Planning Applications, Ribble Valley District
3/09/0355 Time Technology Park, Blackburn Road, Simonstone

HEM East, Ribble Valley
Traffic and Development Engineer
01254 770984

Location Plan

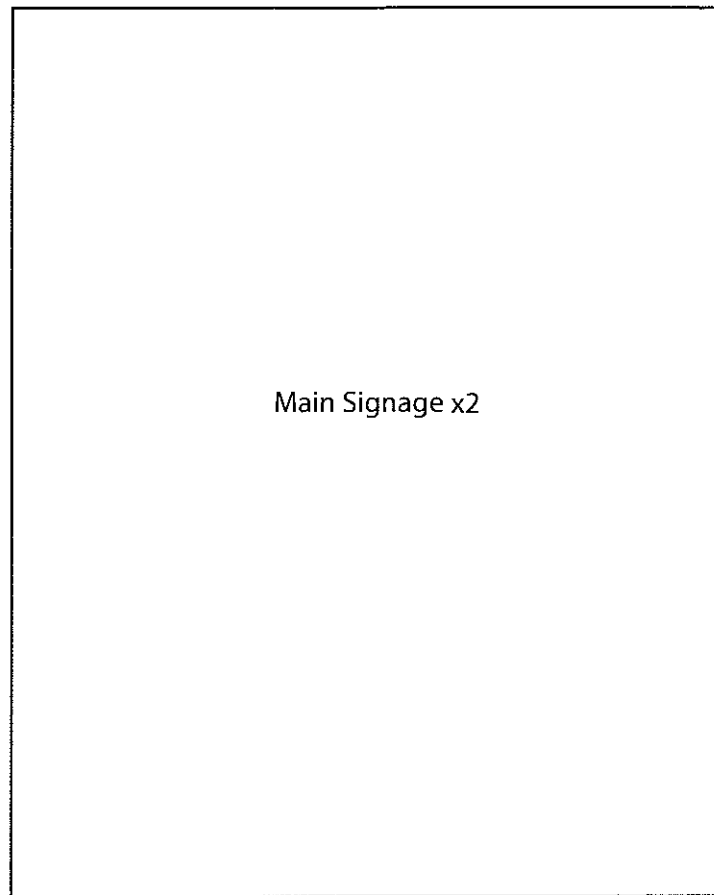
The proposed locations for the signs, flags and hoardings have been set well back from the edge of carriageway and do not interfere with any visibility splays affecting access to these premises.
